SUBJECT: Engineering Review Comment
Mountain View Electric Association Inc. (MVEA)

Project Name: Retreat at Timberridge Filing 4

Project Number: SF1827

Description: Proposed development of 10 residential lots and 1 tract located east of Vollmer Rd. and north of Arroya Ln. in Township 12S, Range 65W, Section 22.

RETREAT AT TIMBERRIDGE
FILING NO 4
JOB NO. 1185.41
FEBRUARY 22, 2024
SHEET 1 OF 3

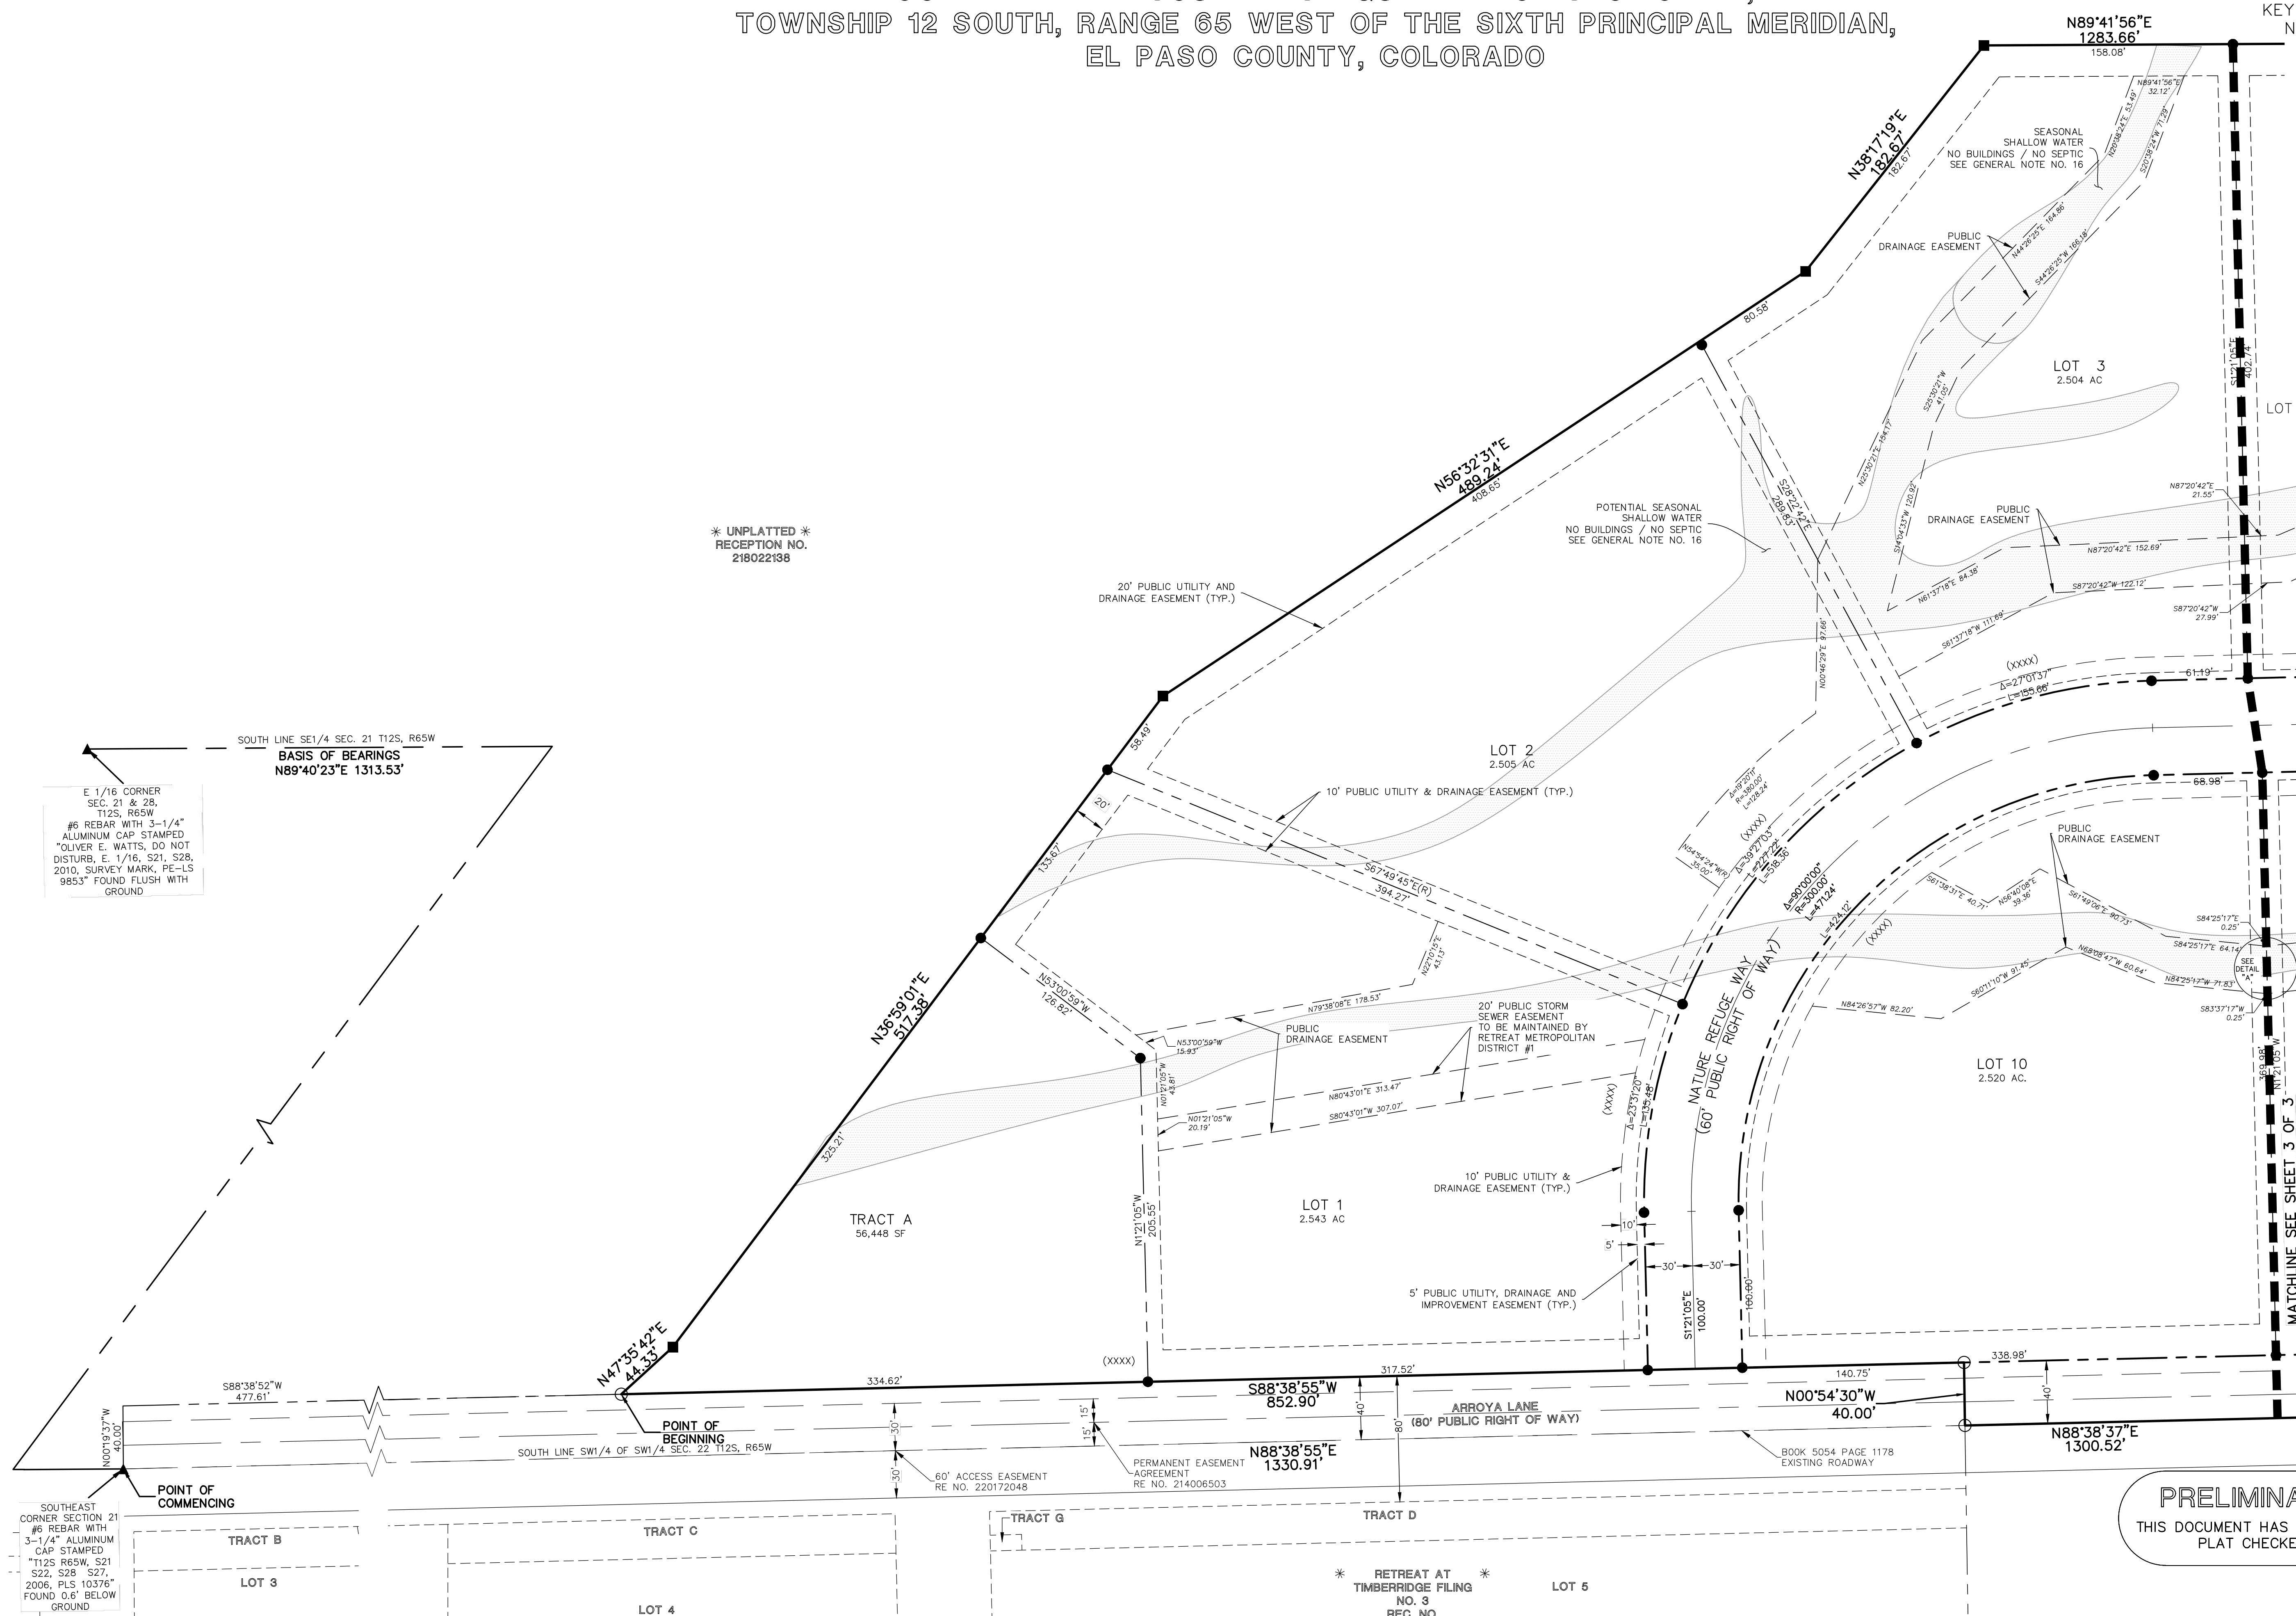
MVEA requests a ten (10) foot front, side, and rear lot utility easement and all tracts, along with a twenty (20) foot exterior utility easement on the plat. This is in addition to any public improvement easement. MVEA also requests the platting of MVEA's existing facilities with easements on the plat. Additional easements may be required.
